Medical Bld. (Contract Zone)

Re: Request for Zone Change: 50 Sewall Street and Corner of Congress Street and
I-295 ramp
Response to Planning Board/ Staff Comments

A/E Project # 04052

In response to comments received from the Planning Board and planning staff, we provide the following information.

TITLE  
North Elevation

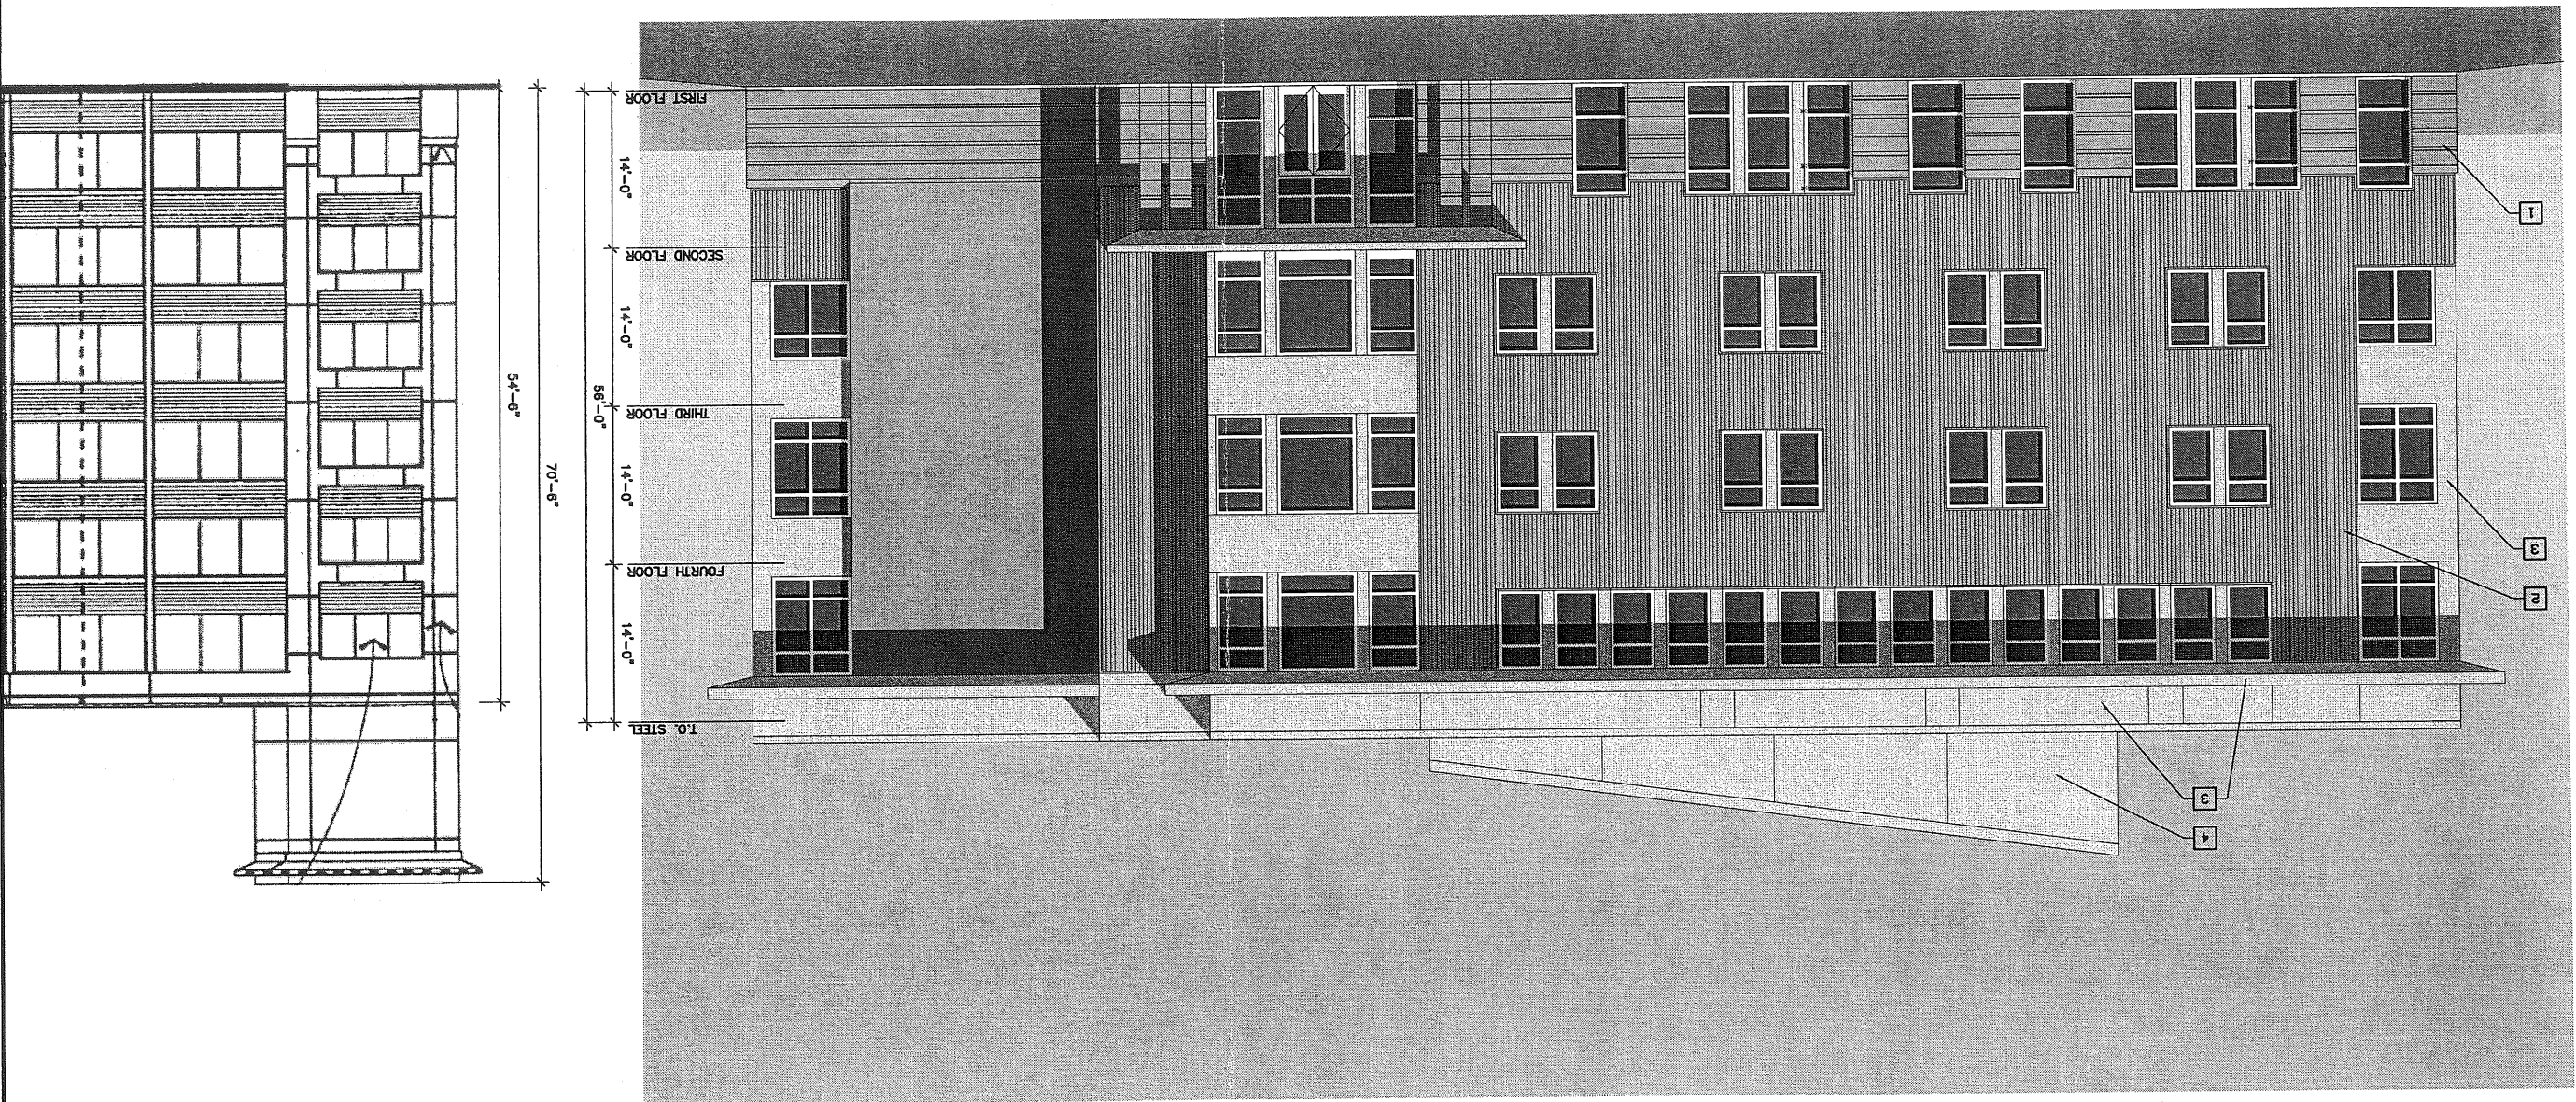
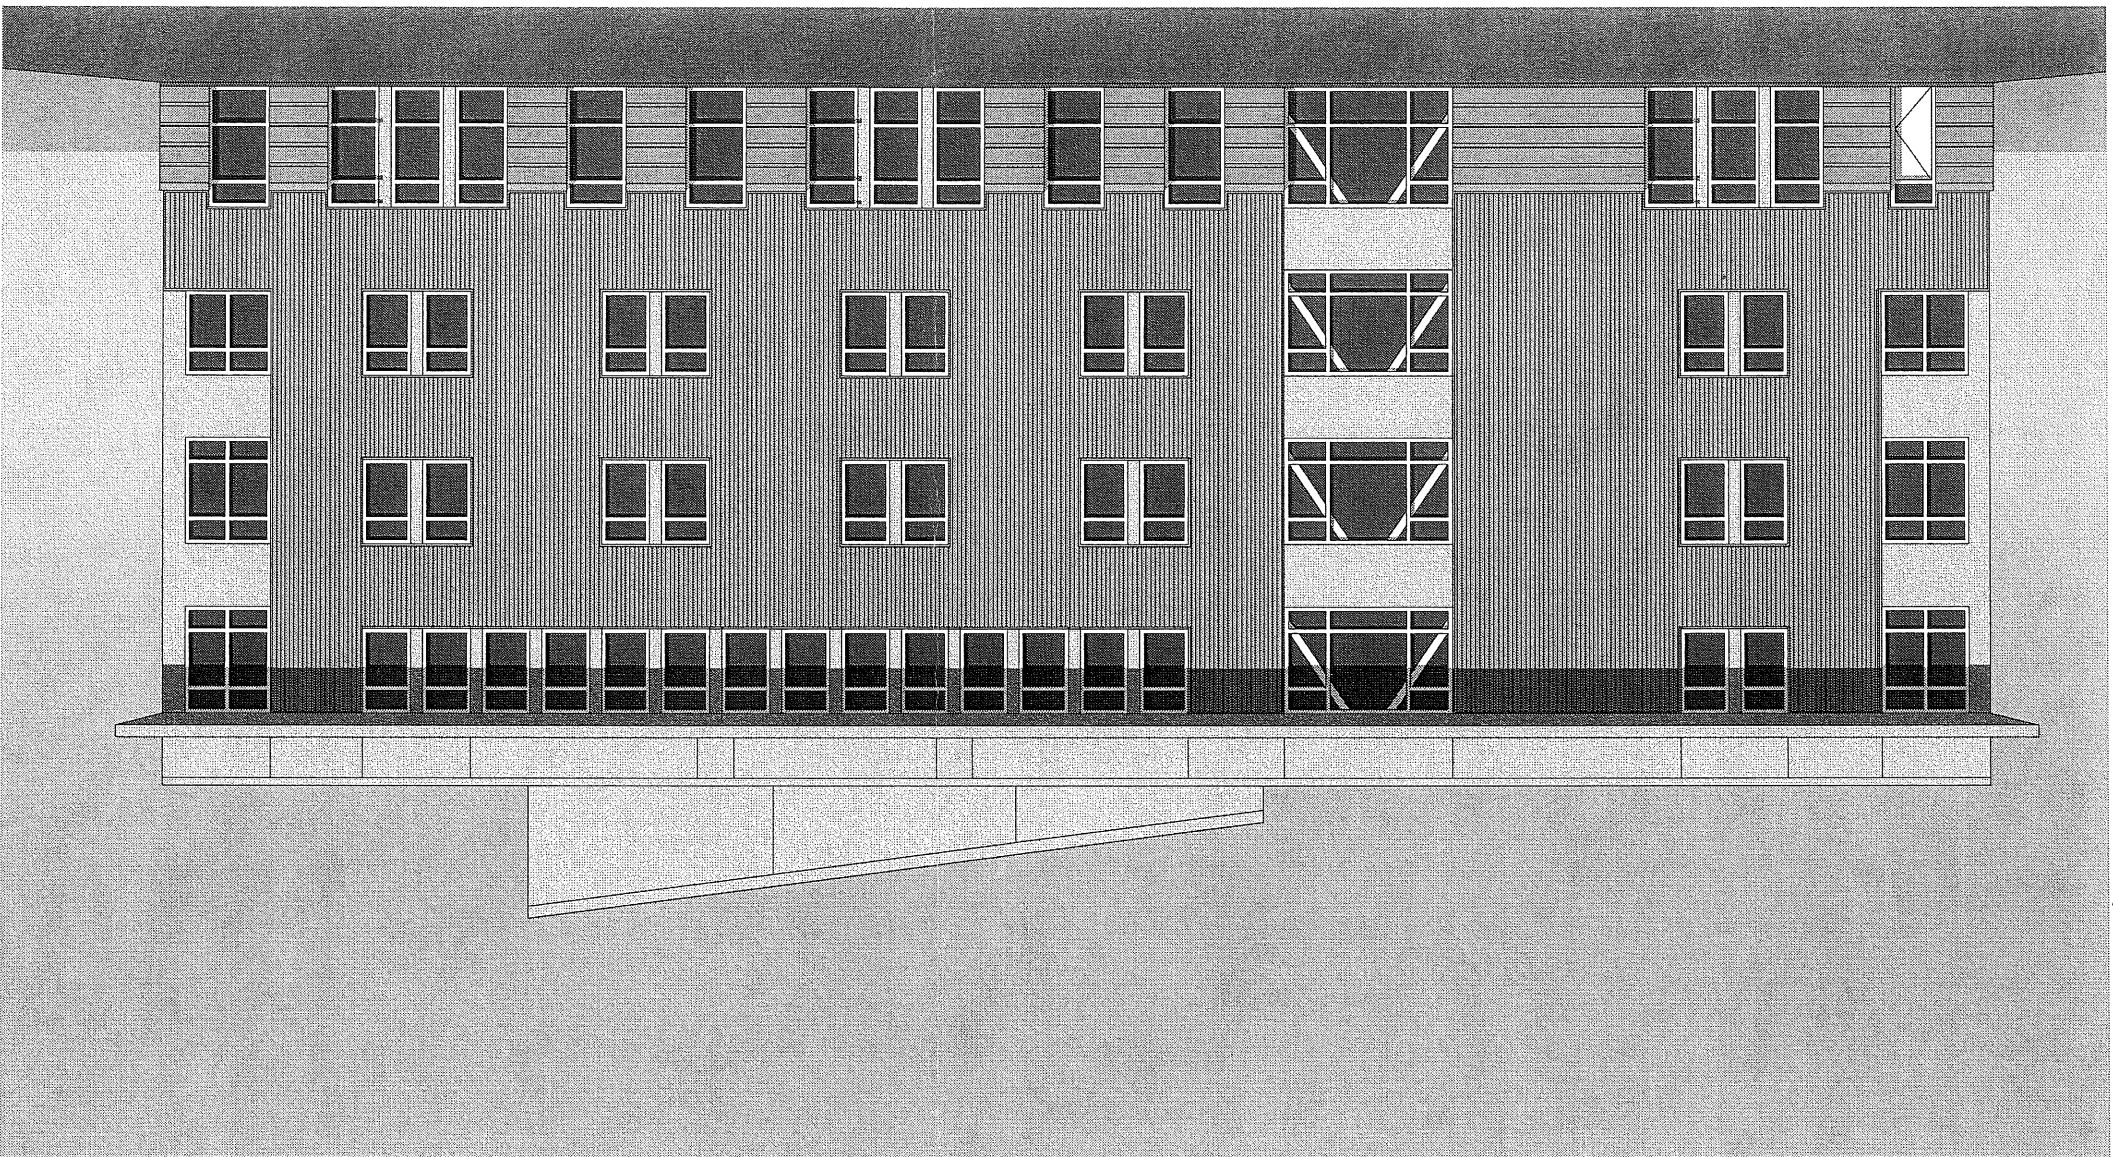
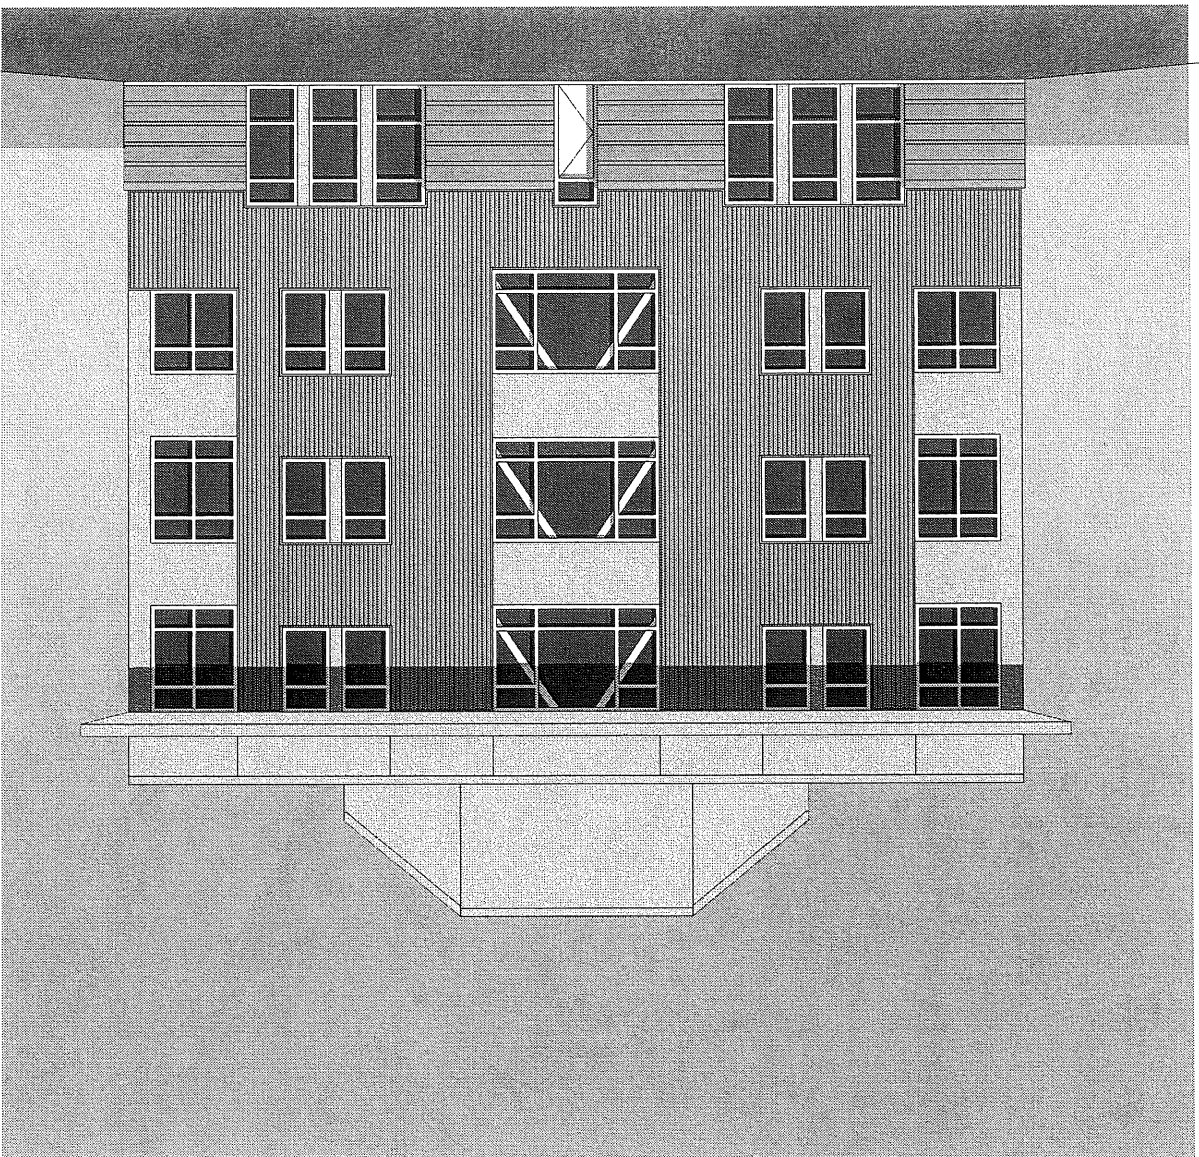
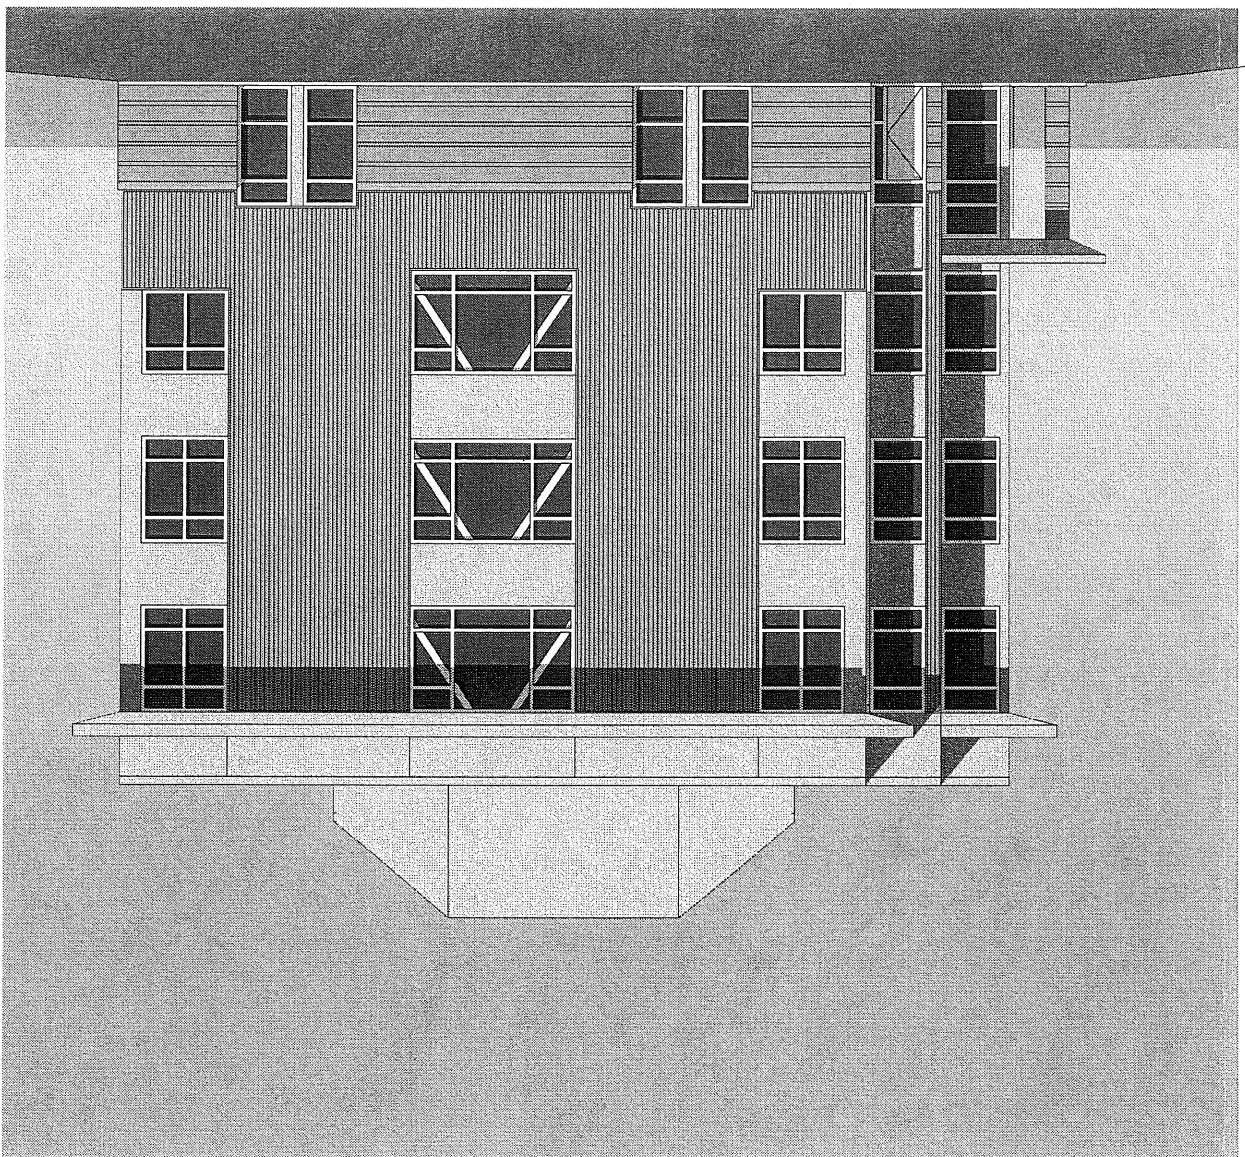
Comment: Why is the applicant seeking a building height greater than the 45 feet allowed on a 1.7-acre lot in the B-2 zone?

Response: The application has been revised to request a maximum height of 60 feet, rather than the 65 feet originally requested. The proposed structure is four stories. Several factors were involved in the establishment of the height of the proposed building. The relationship to the height of adjacent buildings is important, as the Doubletree Hotel is in excess of 60 feet, and the Norway Savings Bank building is about 53' high. The proposed four-story structure also allows a small building footprint, which maximizes green space. Visibility from I-295 is also a factor. The proposed height will allow the building to be one of the first structures viewed by northbound vehicles on the Interstate. Strong architecture will aid in making the proposed building a part of the gateway to Portland.
